Transport
Roads & Maritime
Services

Our Reference: SYD16/00625/10
(A23360272)
DP&E Ref: SSD 7684

**NOTIFICATION OF RESPONSE TO SUBMISSIONS
COCKLE BAY WHARF (SD 7684)**

AMENDED CONCEPT PROPOSAL SSD7684 - STAGED REDEVELOPMENT OF COCKLE BAY WHARF - 241 – 249 WHEAT ROAD, COCKLE BAY DARLING HARBOUR

ATTACHMENT B  
VEHICLE TURN PATHS

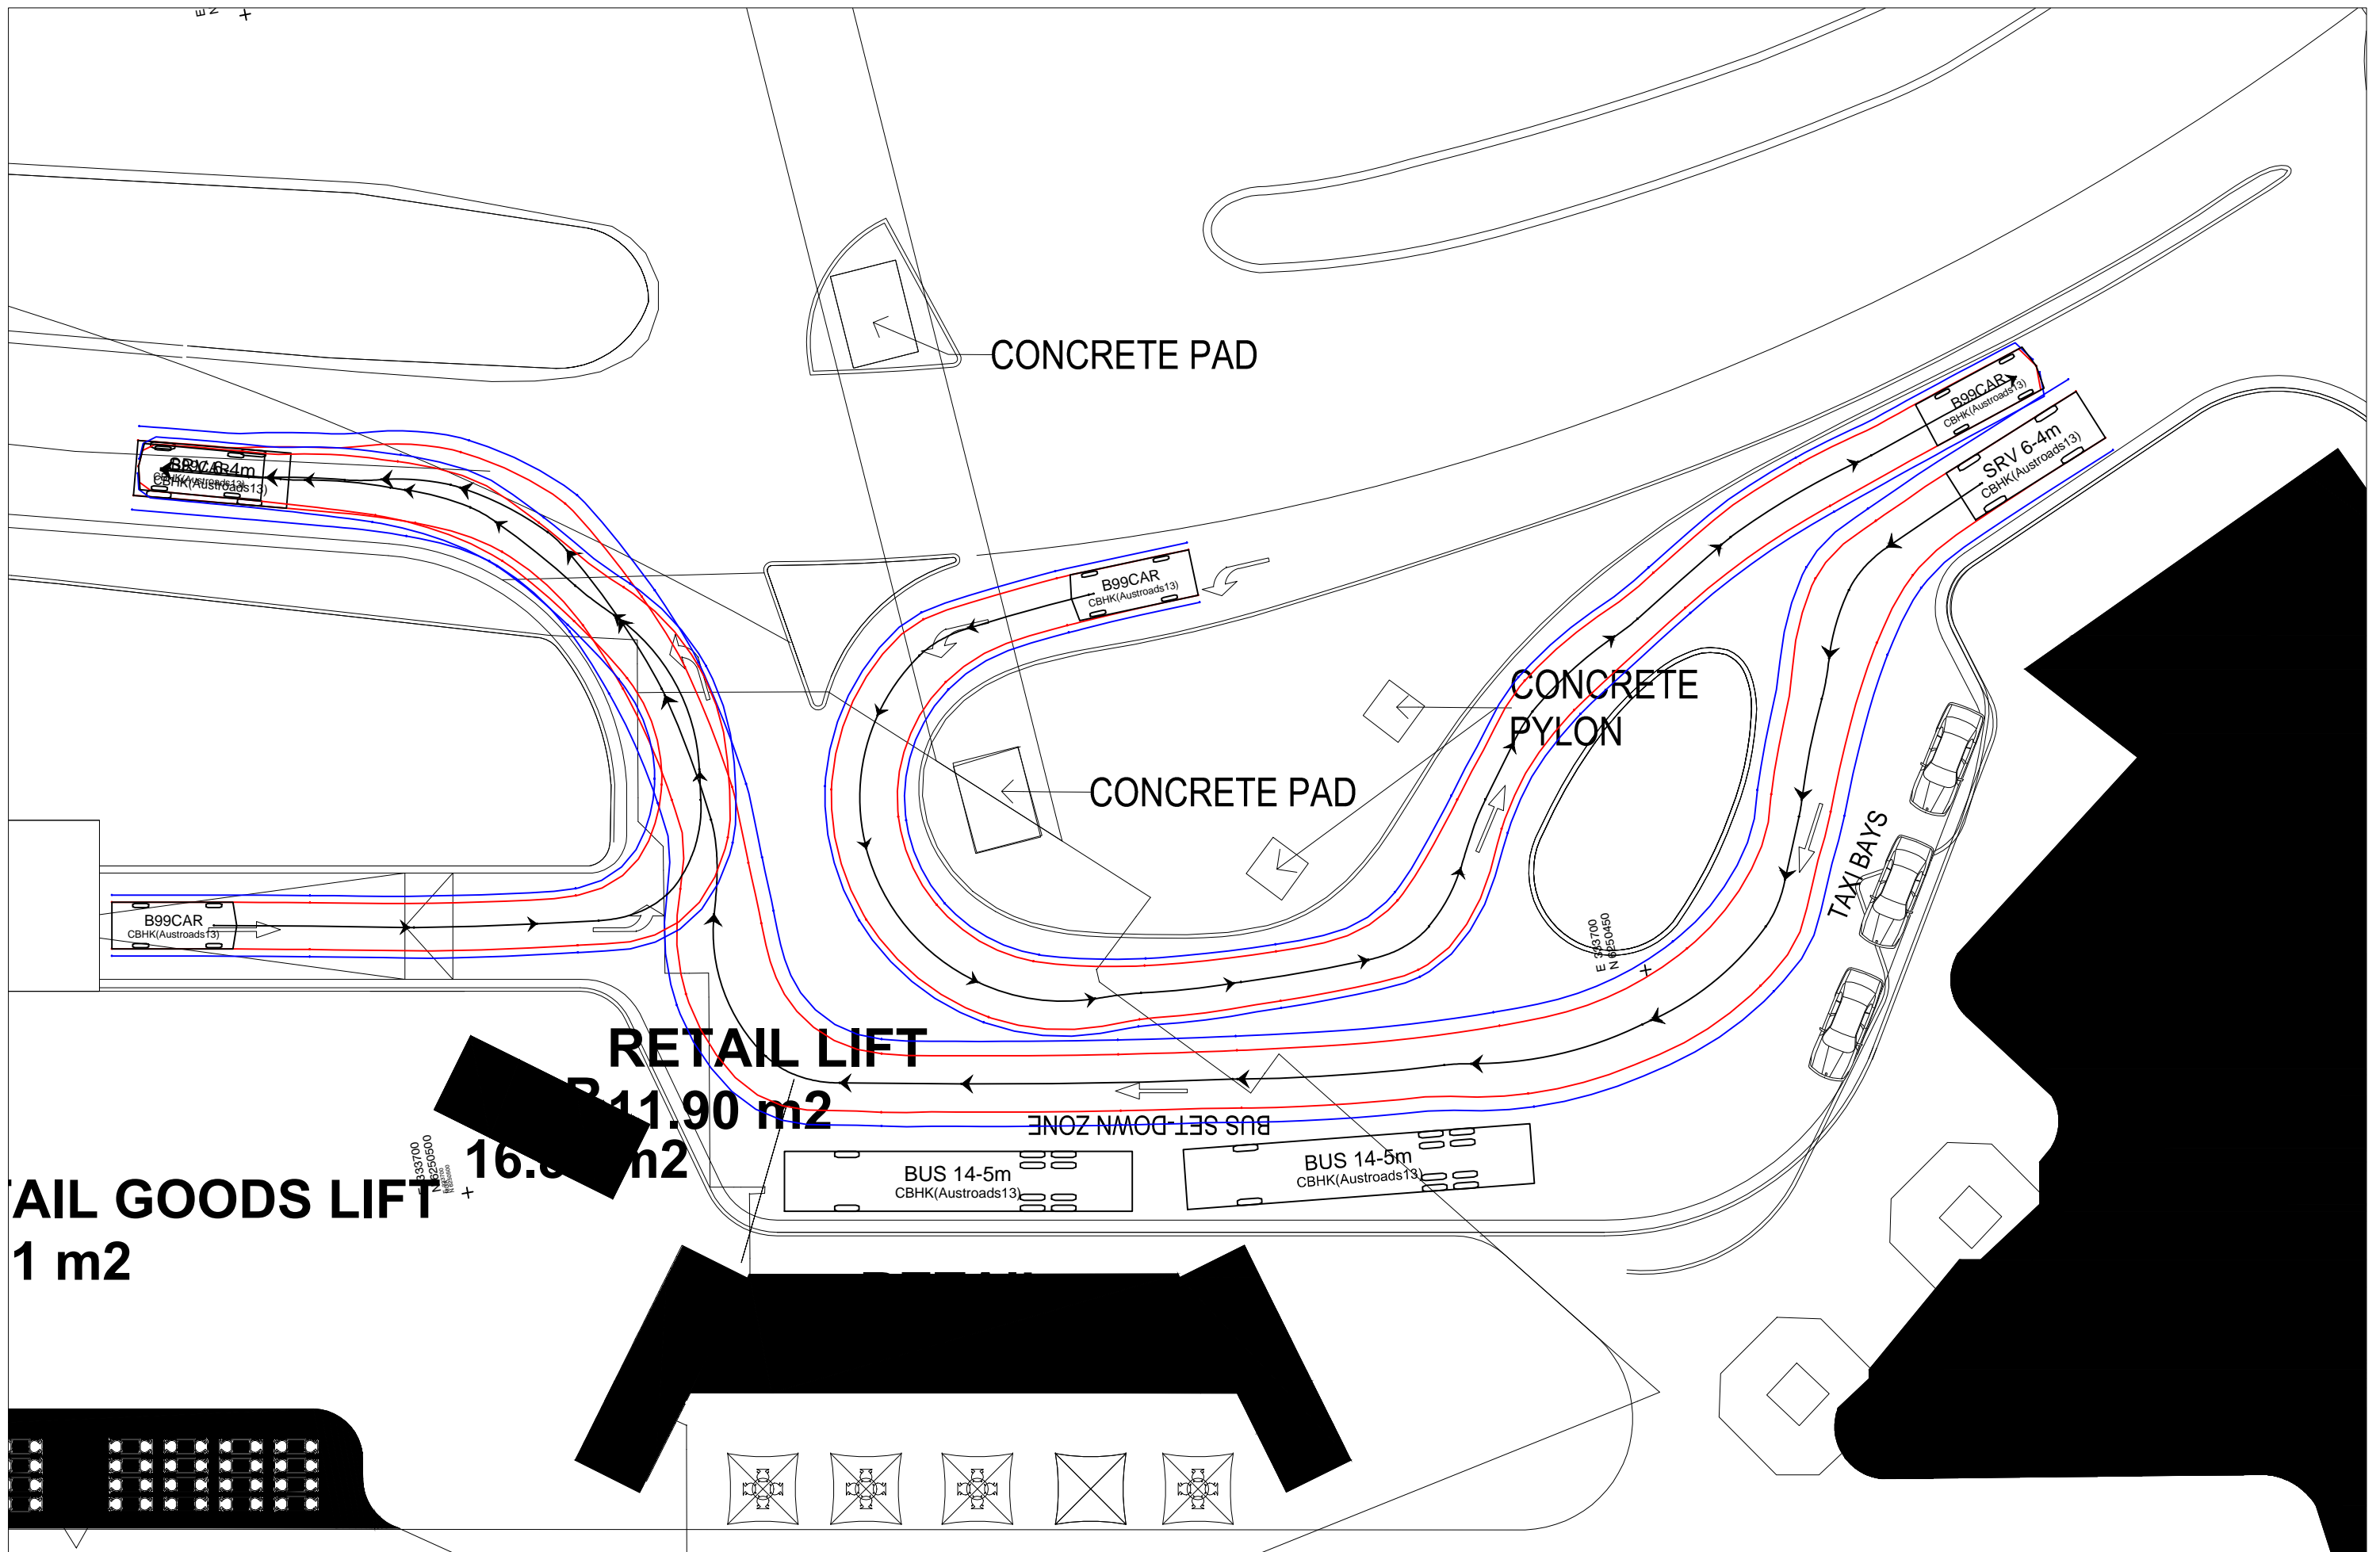
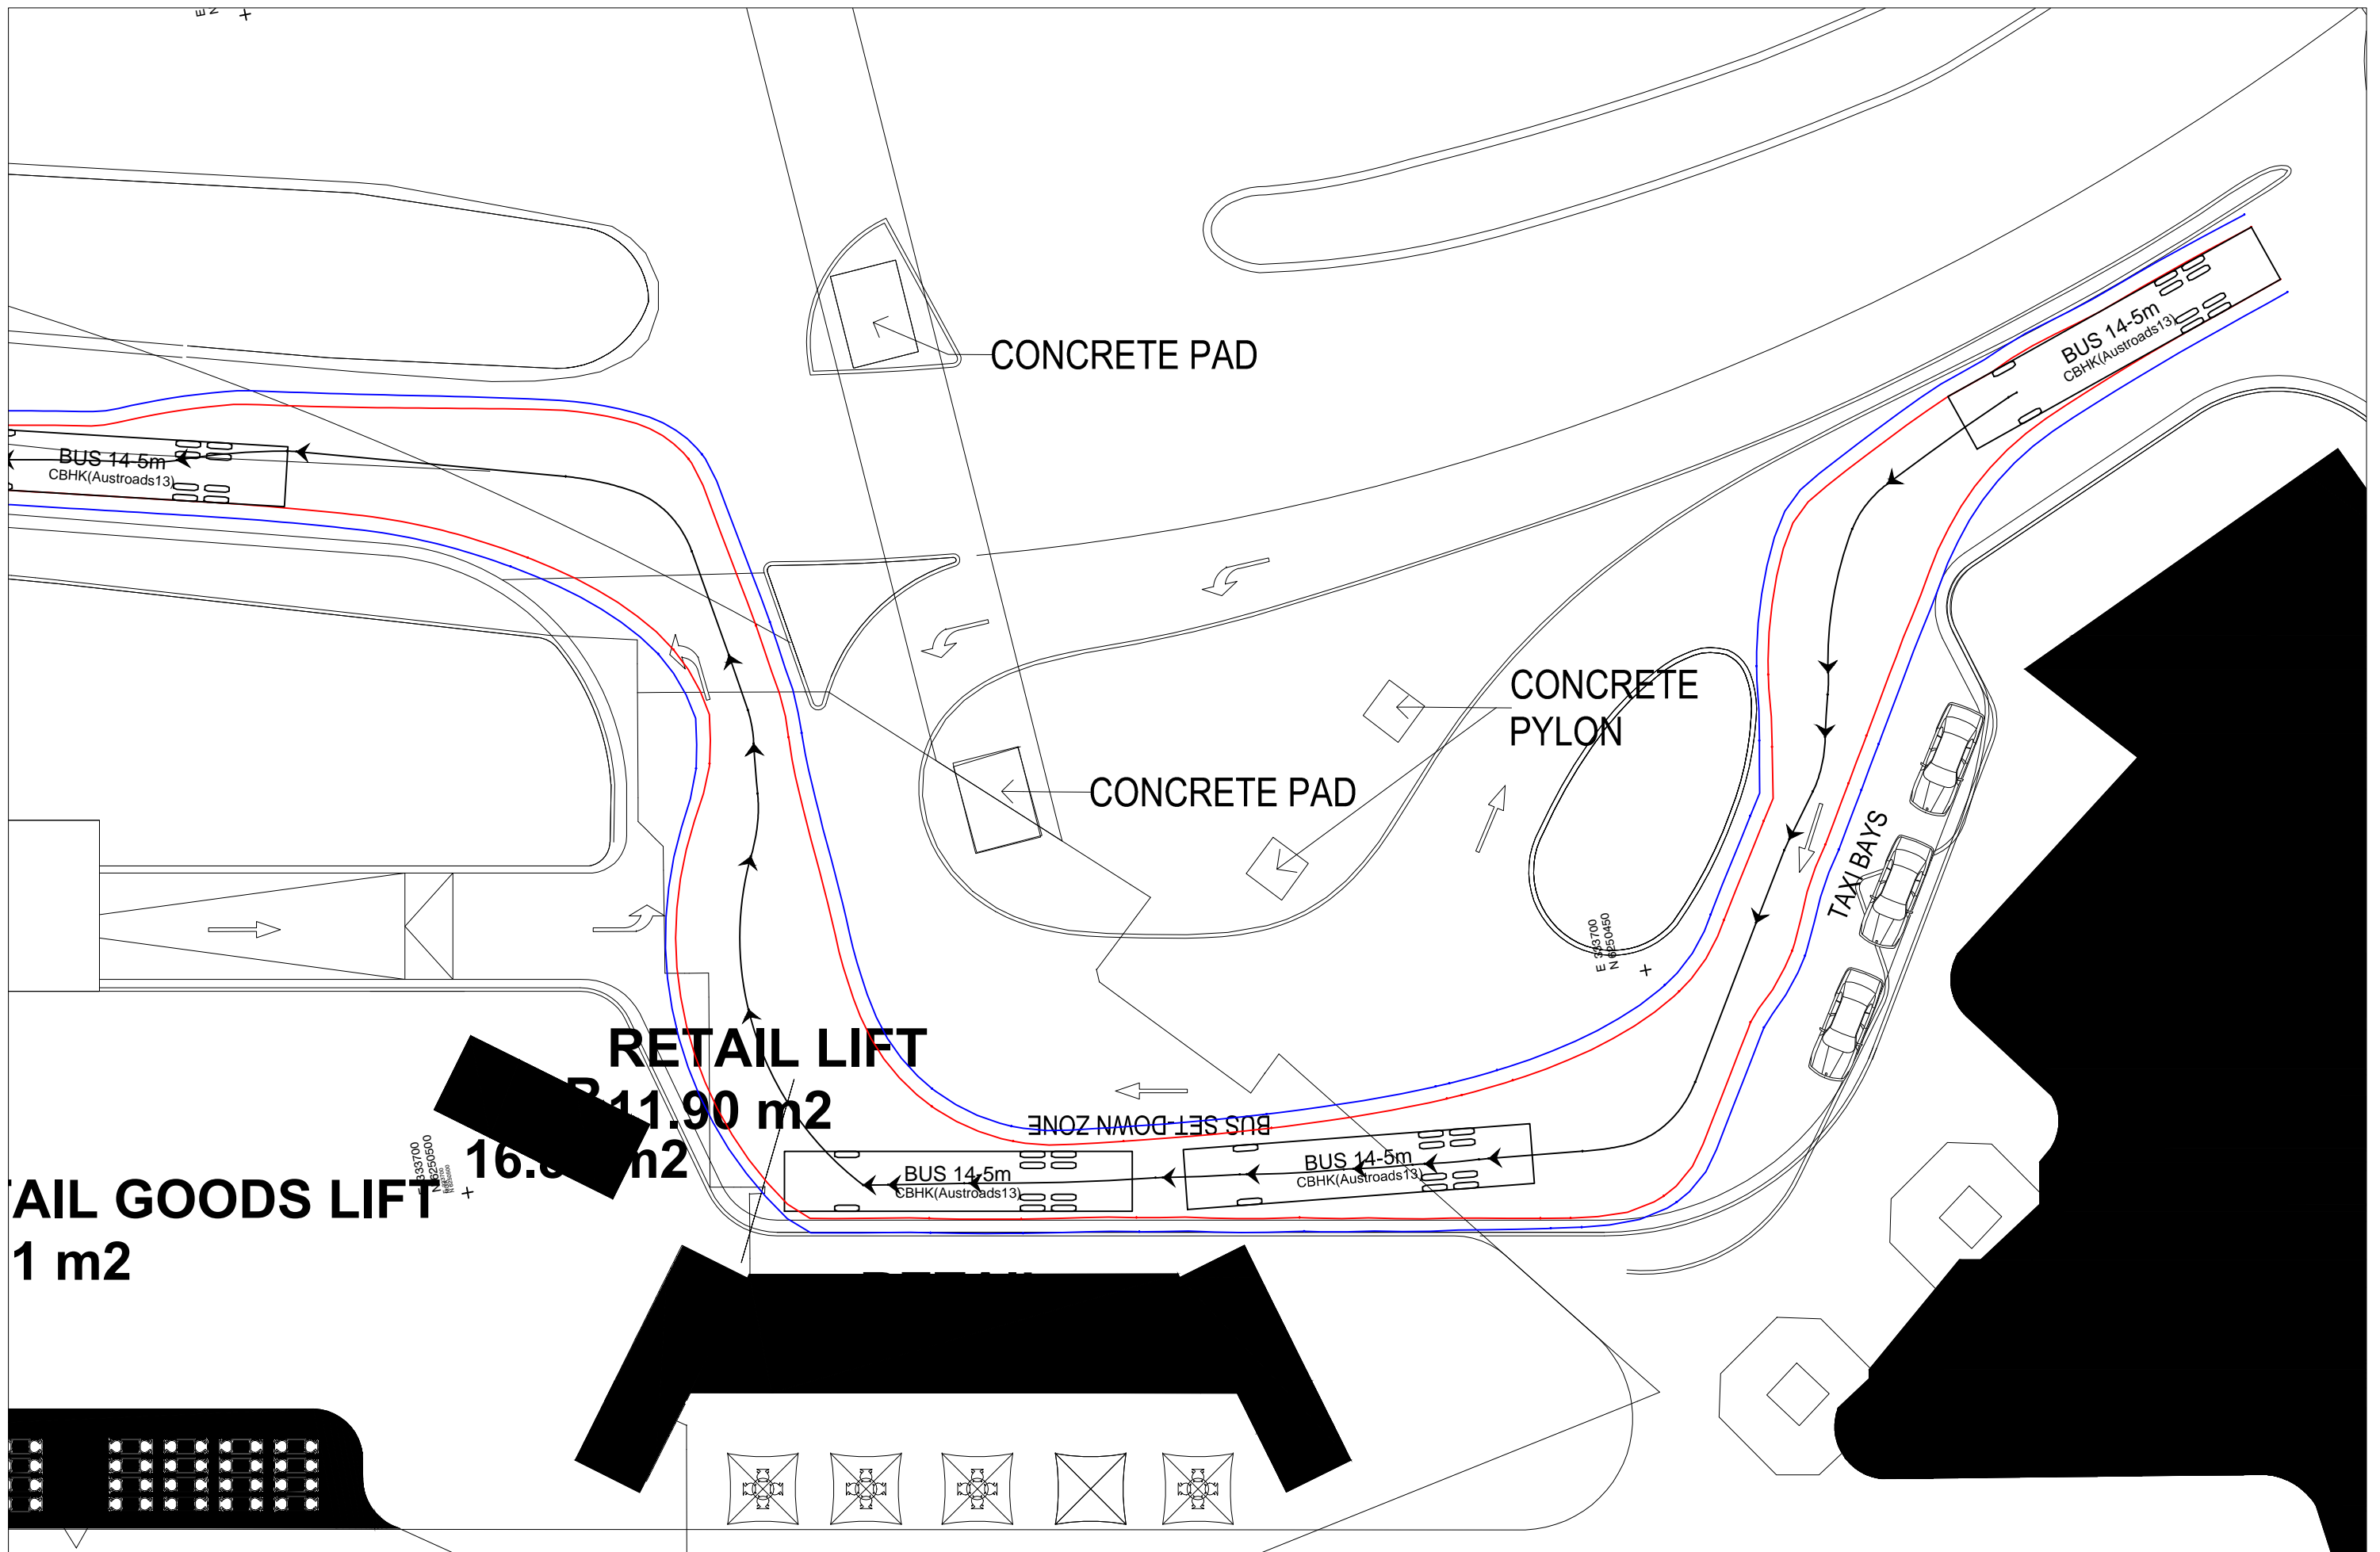
- vii. With relation to trucks servicing the site, only a 8.8m truck turning path accessing the loading dock area has been shown. Roads and Maritime would require swept paths for 12.5m trucks to be demonstrated.
